**Your Ref:** OWPC20099  
**Our Ref:** R/190/18/PL 31-07-2018  
**Please ask for:**  
Mrs A Gardner

Demolition of 1 No. existing house & grounds & erection of 2 No. new detached dwellings. This application may affect the character & appearance of the Station Road, East Preston Conservation Area.

St Marys Close Hurst Road Rustington

Thank you for your internet representation made on 6th October 2018 which has been recorded as '**an objection**' with the comments as follows:

Drawing Title:
ADDITIONAL DWELLINGS
BLOCK/ SITE PLAN

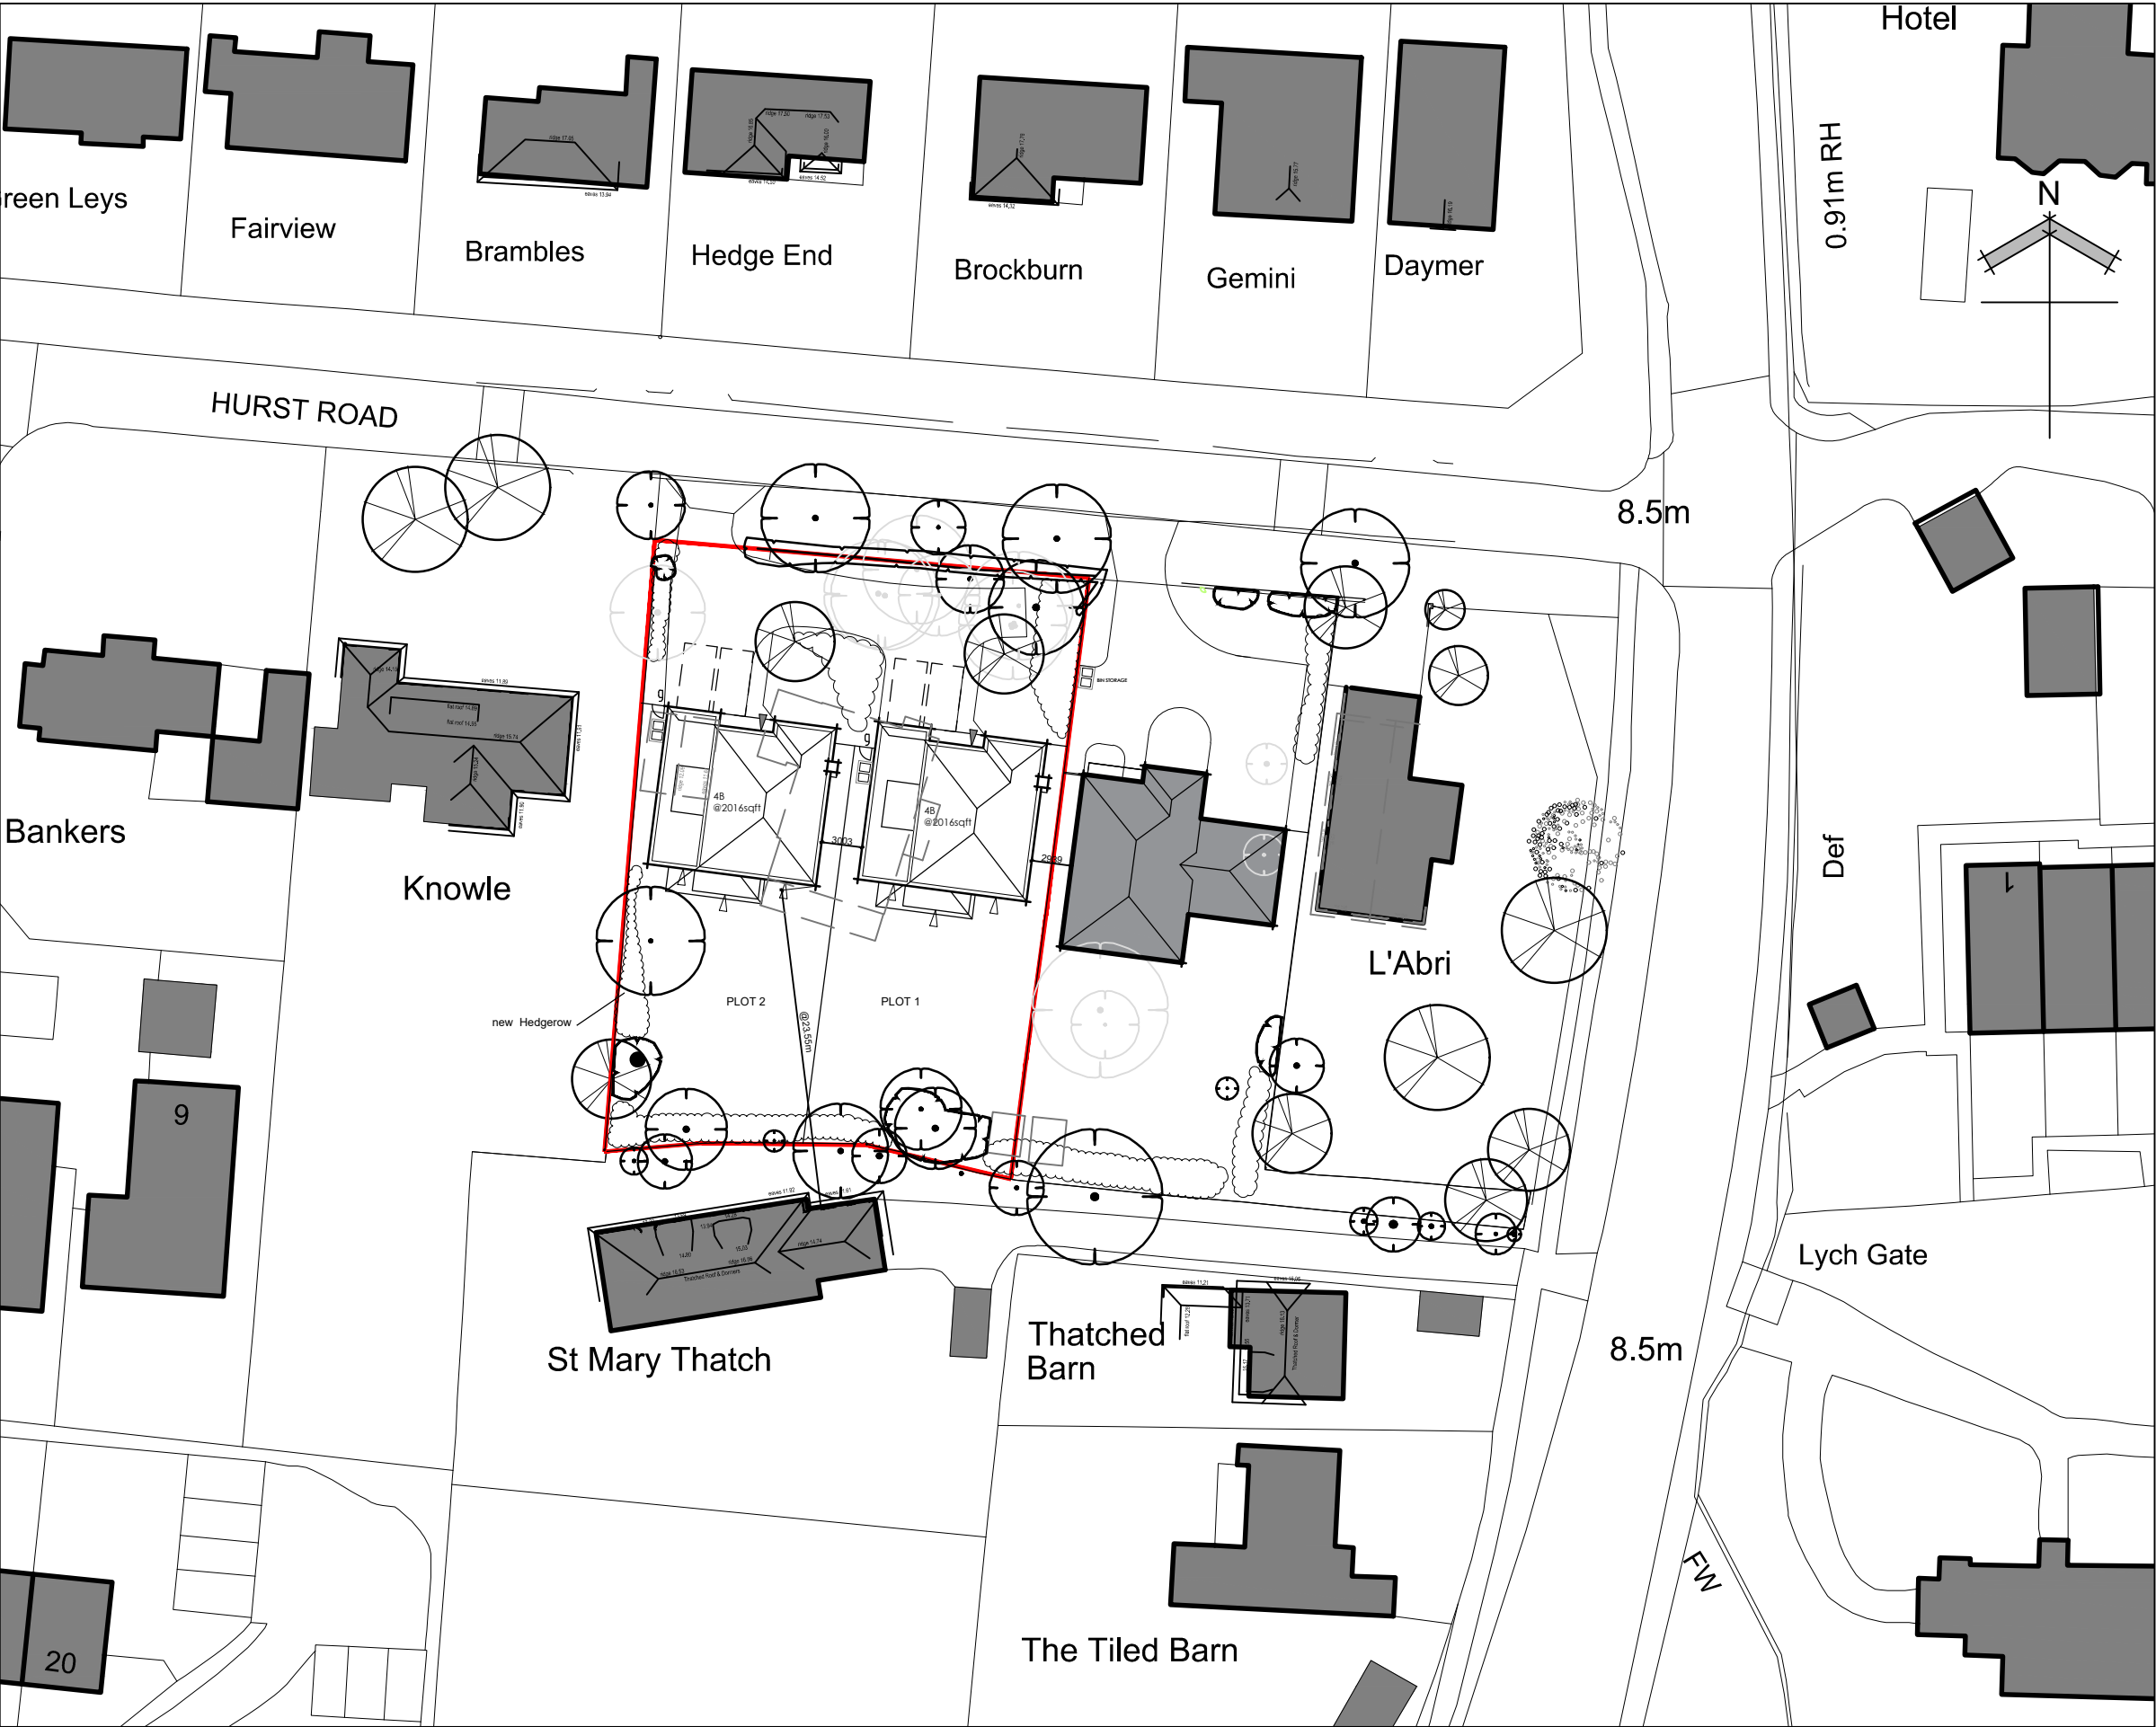
*Also it is worth pointing that all the houses on the road have separate and private drives why couldn't this application follow suit?*

Drawing Title:
ADDITIONAL DWELLING
PLOTS 1 & 2
ELEVATIONS

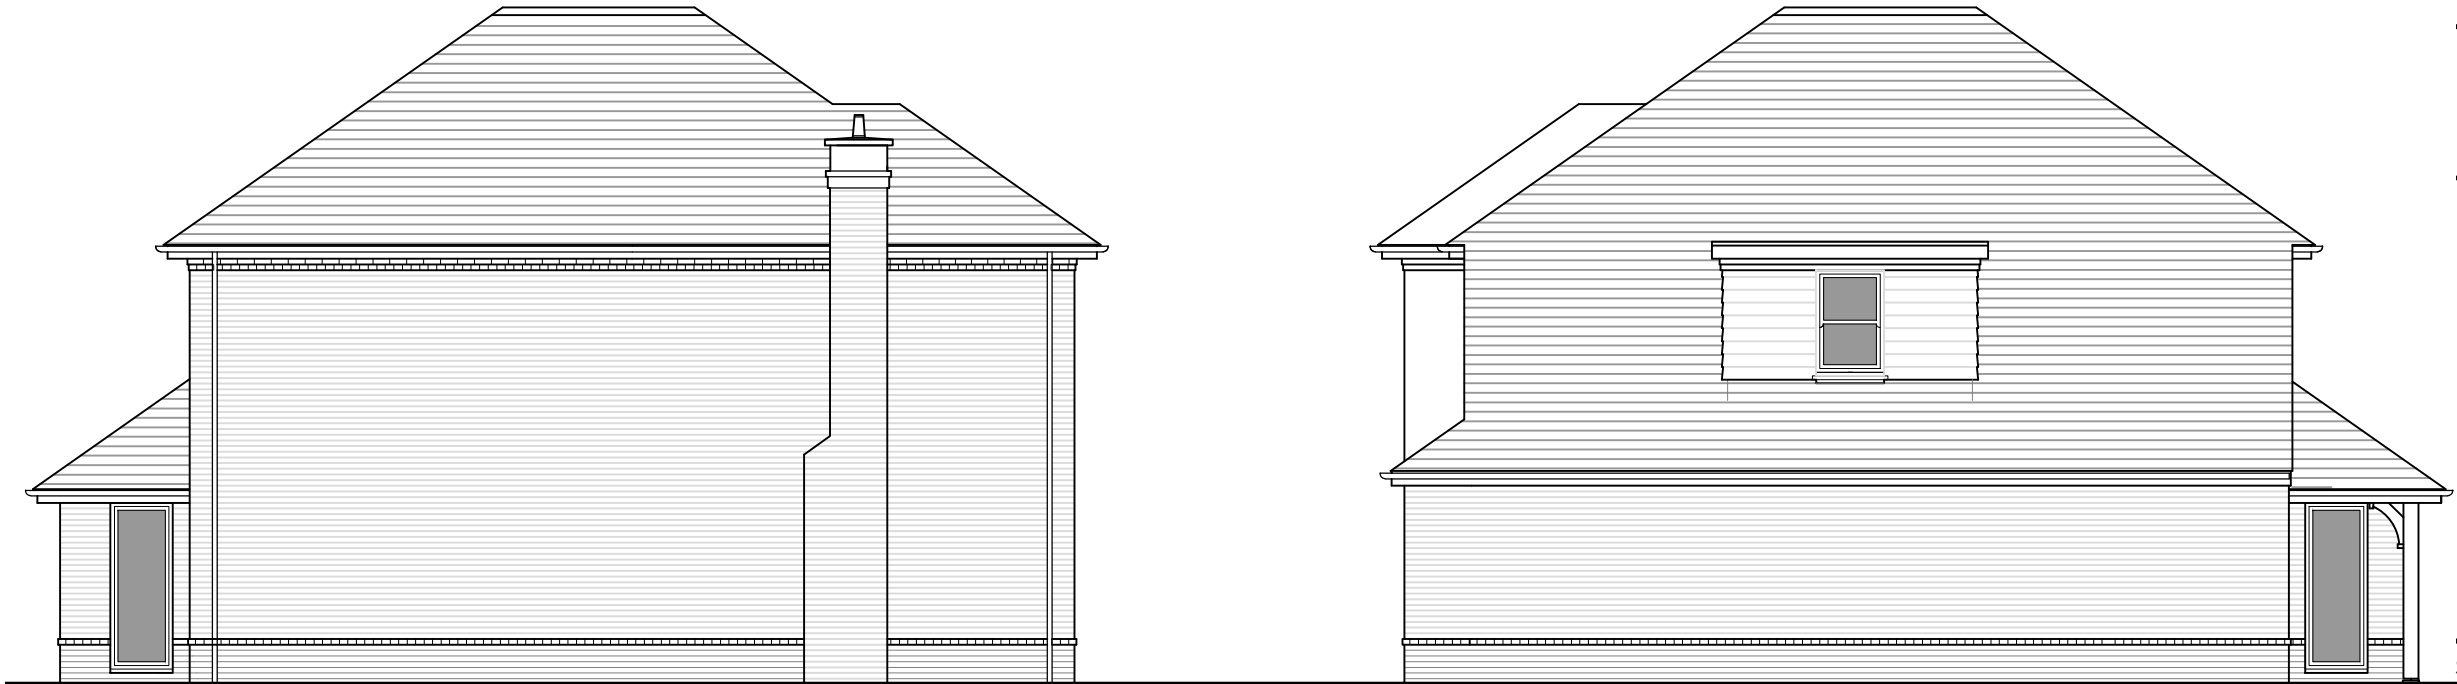
*Two identical houses with same elevation and same orientation (not even mirrored!) do nothing to espouse the character of the road nor enhance the street scene or give any kudos to MJH, surely a company of their calibre and experience must have more designs in their coffers.*
